Subject: RE: BE/117/18/DOC - Discharge of Conditions 5, 6, 14 + 23 - New Barn Lane, North Bersted

Subject: RE: Discharge of Condition 5 BE/18/17/PL - New Barn Lane, North Bersted

Condition 5 (surface water drainage)

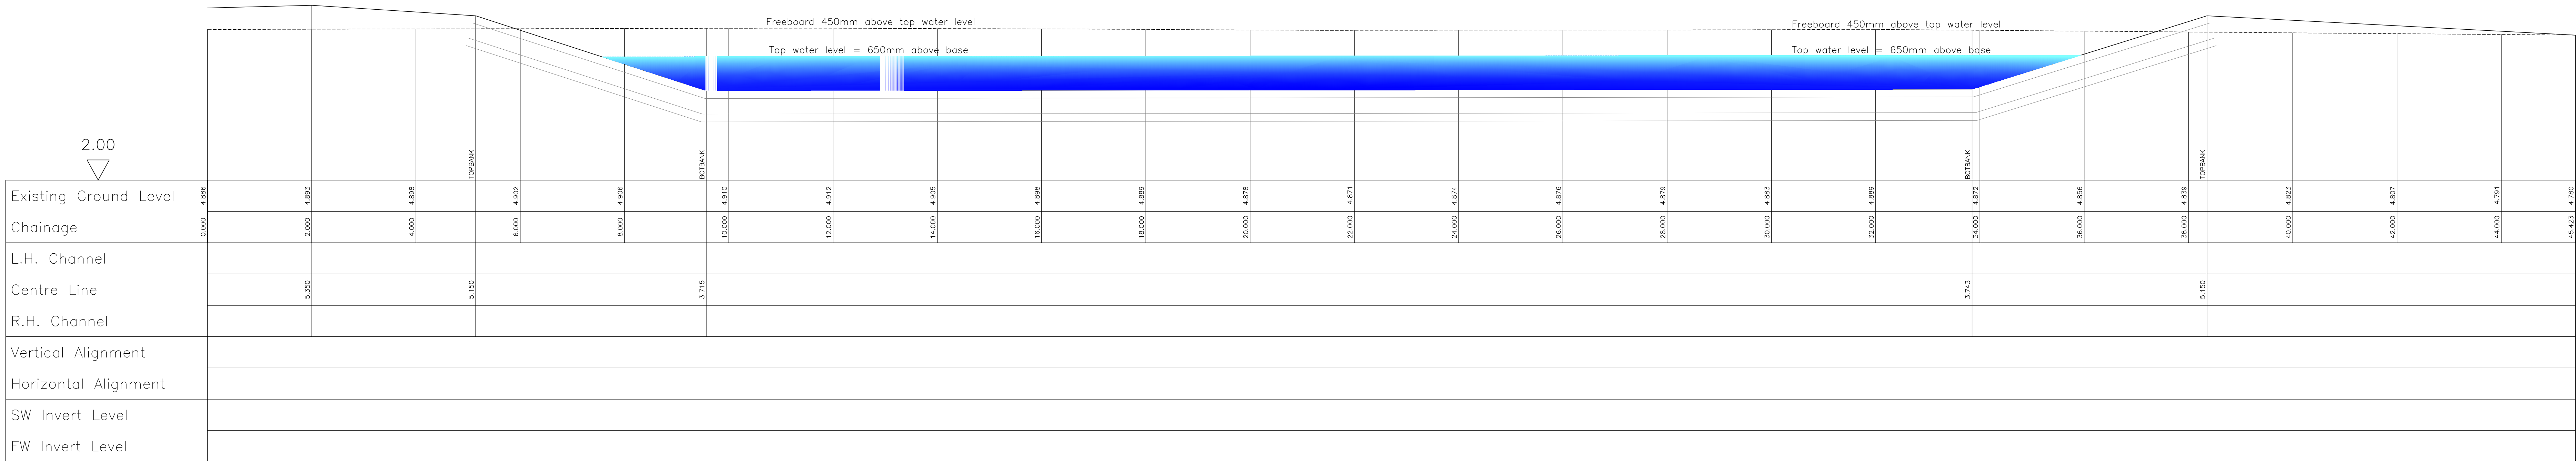
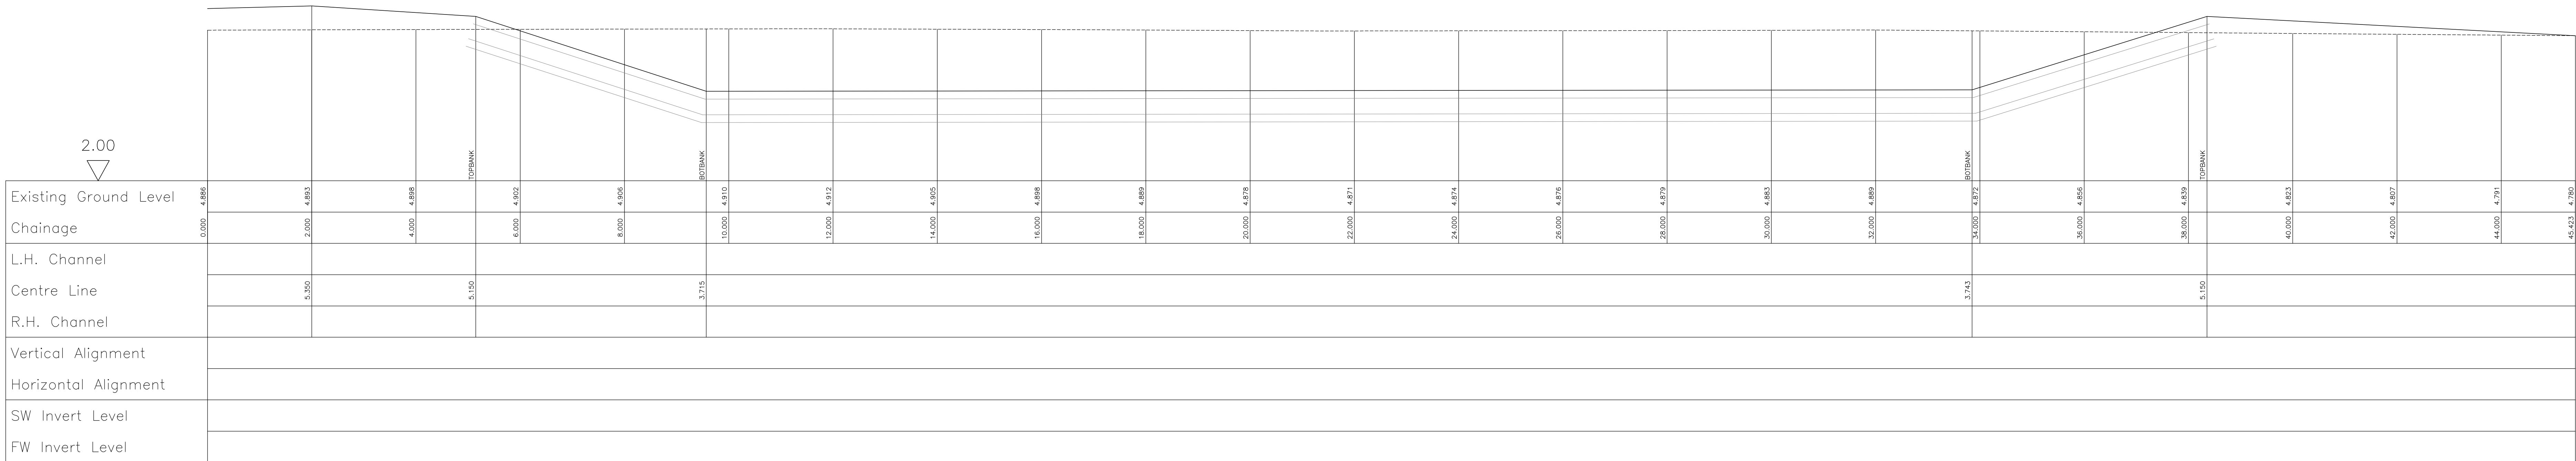
However, the depth of groundwater displaced in your calculations is incorrect. You are displacing 1.7m of groundwater, not 1.4m. This means that you do not have sufficient resisting forces. Please revise.

I note that the revised pond detail means that you are now displacing extra groundwater. It would be good to get some revised calculations submitted just to show that you have considered this and that design is okay.

- ~~c) As I stated back on the 5th December it is not acceptable to have the inlet into the pond below the turf layer. Please revise this.~~

~~MJA Response—Noted. Swale sections revised, concrete ditched channel added to details; Please revise the detail to show that the ditched channel will be embedded in concrete.~~

- ~~d) Please model the pond invert level as the turf level.~~

~~MJA Response—It was not altered from previous revisions, refer to sections of drawing LMS232-1011 revision J, the depth area input for the pond has not been changed to account for the change in cross section of the pond. Please update this to ensure consistency between MicroDrainage and plans. For example you do not have 376m² at 3.547m AOD.~~

- ~~e) Layouts need to be updated at the pond to show formation and finish level. Currently the pond is undulating significantly, I would like to see this revised to be smoother.~~

In reference to your email dated 25.01.19, we have calculated the uplift forces as requested.

In addition, a supporting statement, produced by one of our structural engineering colleagues is enclosed. We have also updated drawing LHS232-1011 to tally with the amendments made to the calculations.

~~MJA Response—Detail revised as instructed, refer to drawing LMS232-1011 revision K. Okay.~~

~~MJA Response—Noted, MicroDrainage calculations revised. Okay.~~

~~MJA Response—Noted, Pond and sections revised; Okay.~~

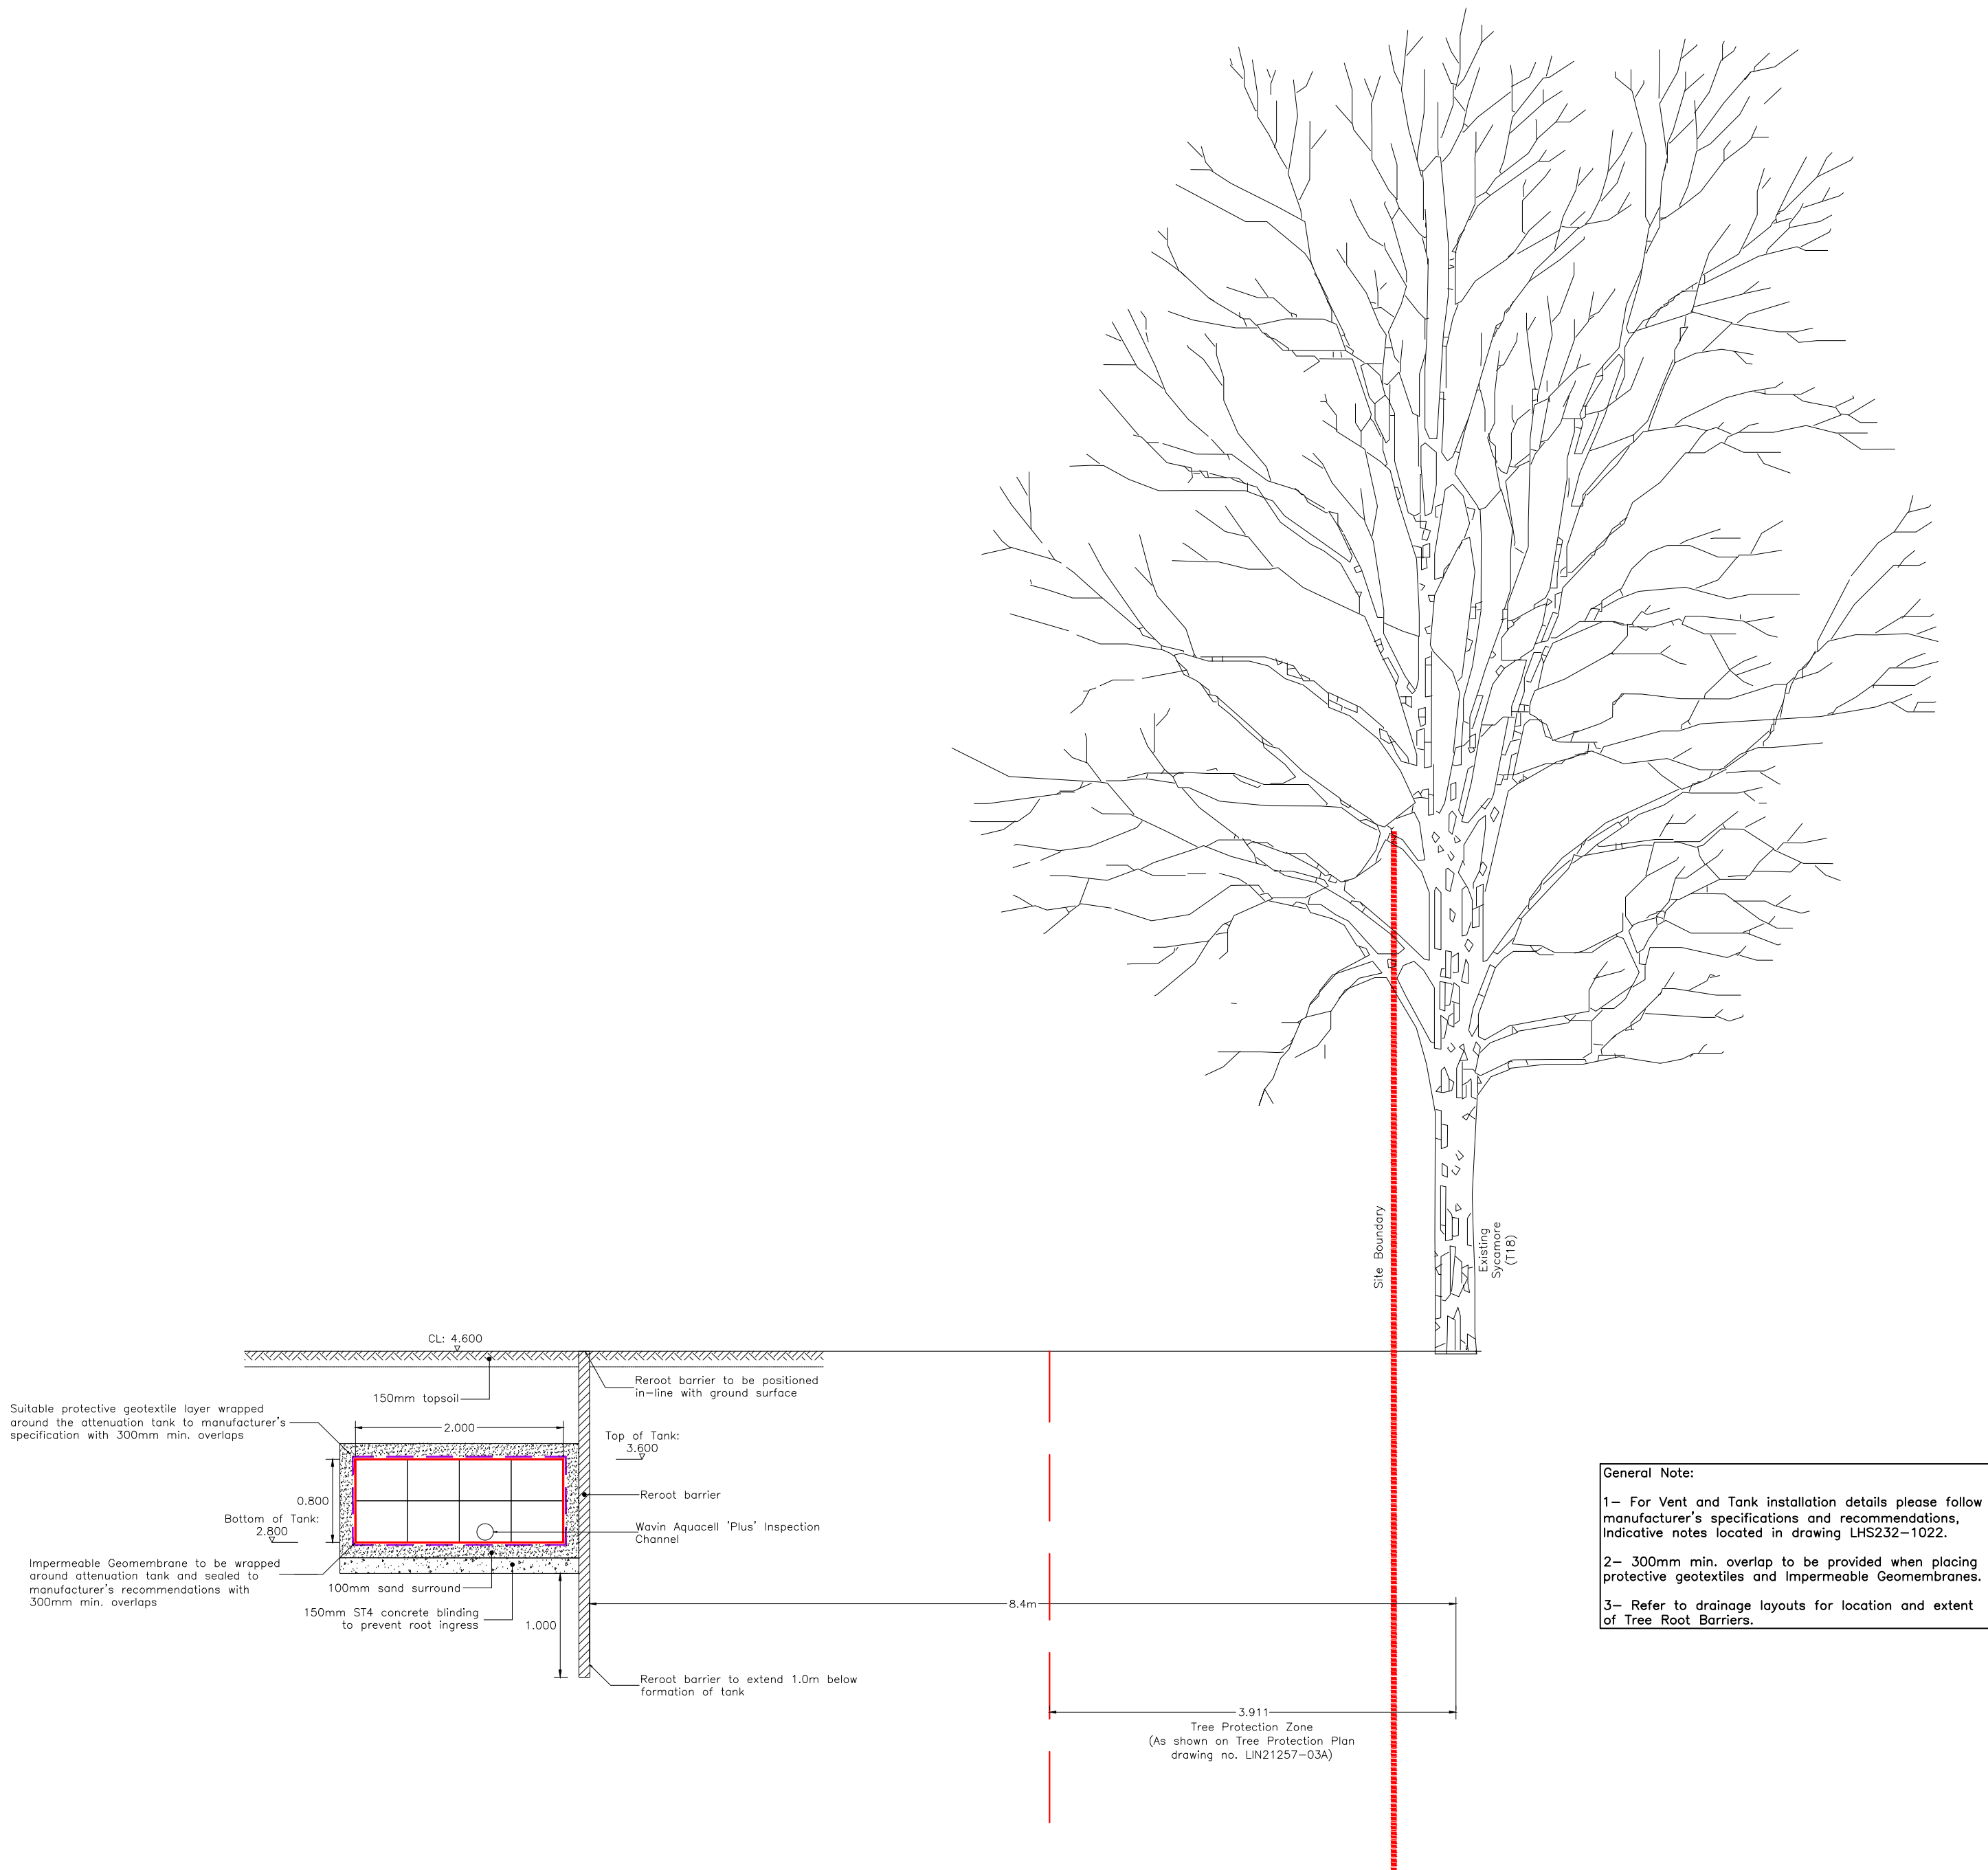
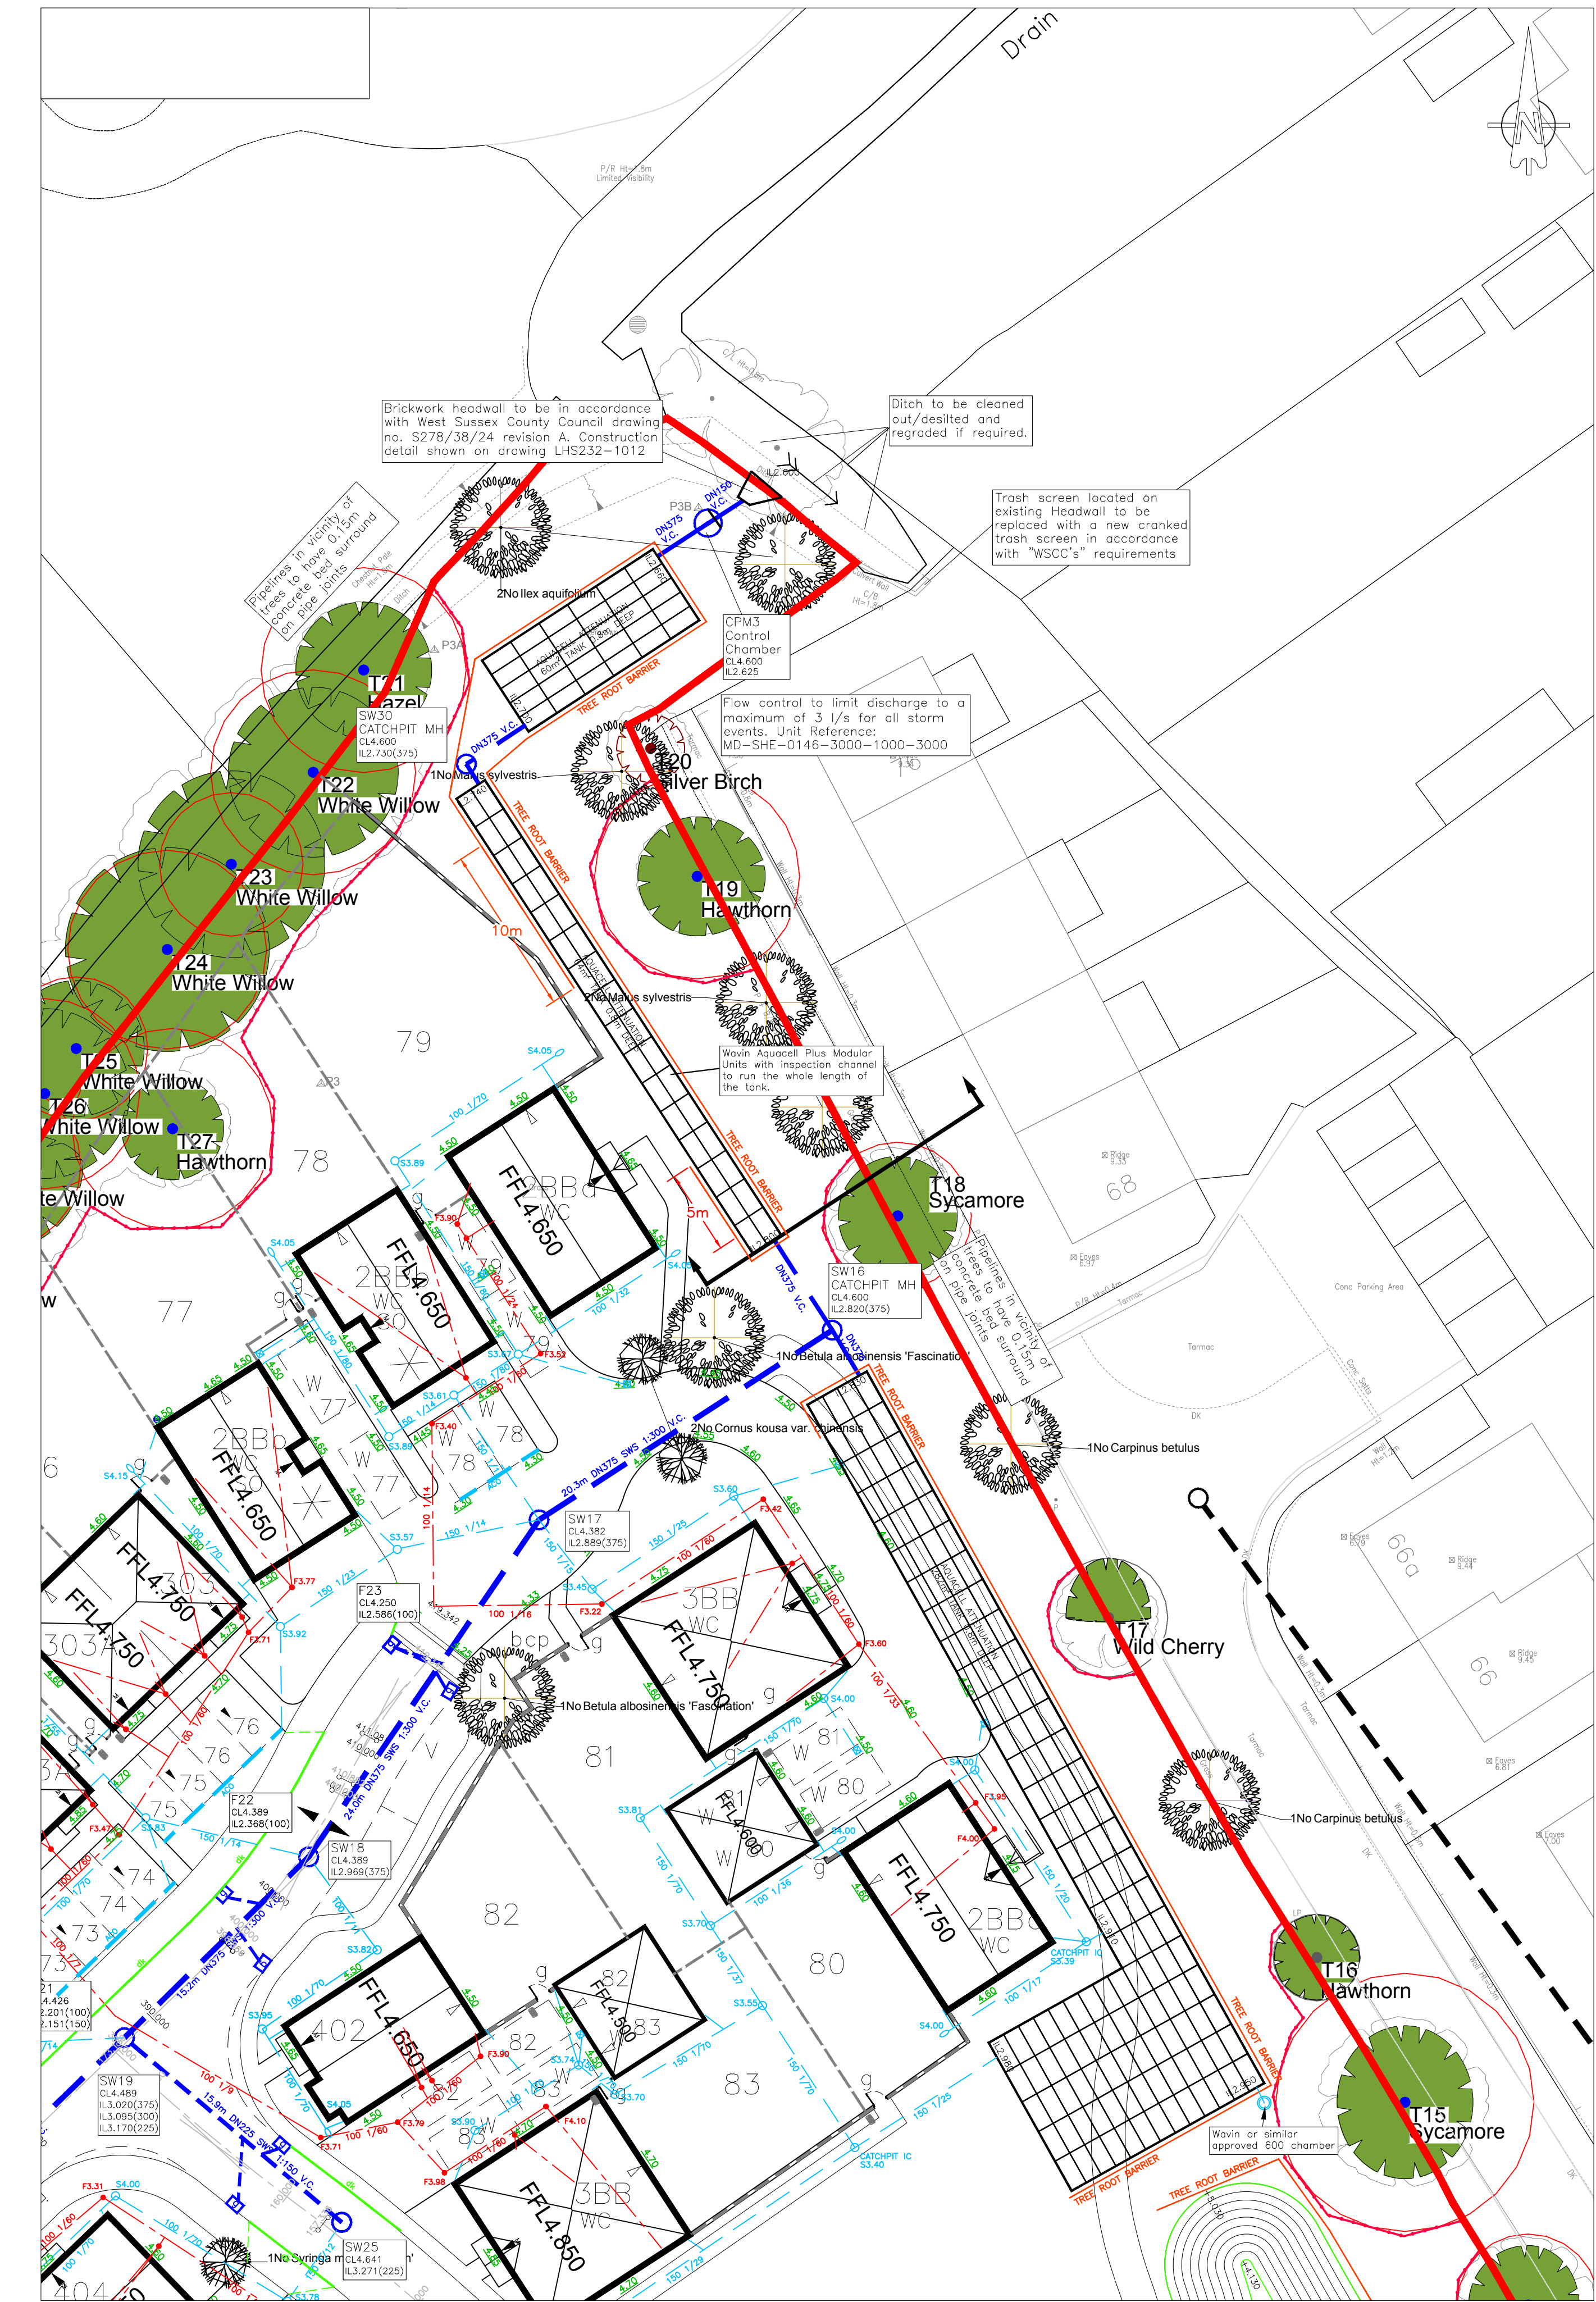
1. The root protection barrier will need to extend to ground surface.

2. 75mm of binding concrete is insufficient. Please provide 150mm of ST4 concrete.
3. Please detail the requirements for inspection and replacement of the root protection barrier within the maintenance manual.
4. 150mm concrete bed and surround will need to be provided at all pipes joints within potential root zones.
5. How are you protecting the pond liner from root ingress?

MJA Response—Noted, root protection barrier extended to ground surface; Okay.

MJA Response—Noted, detail revised as instructed; Okay
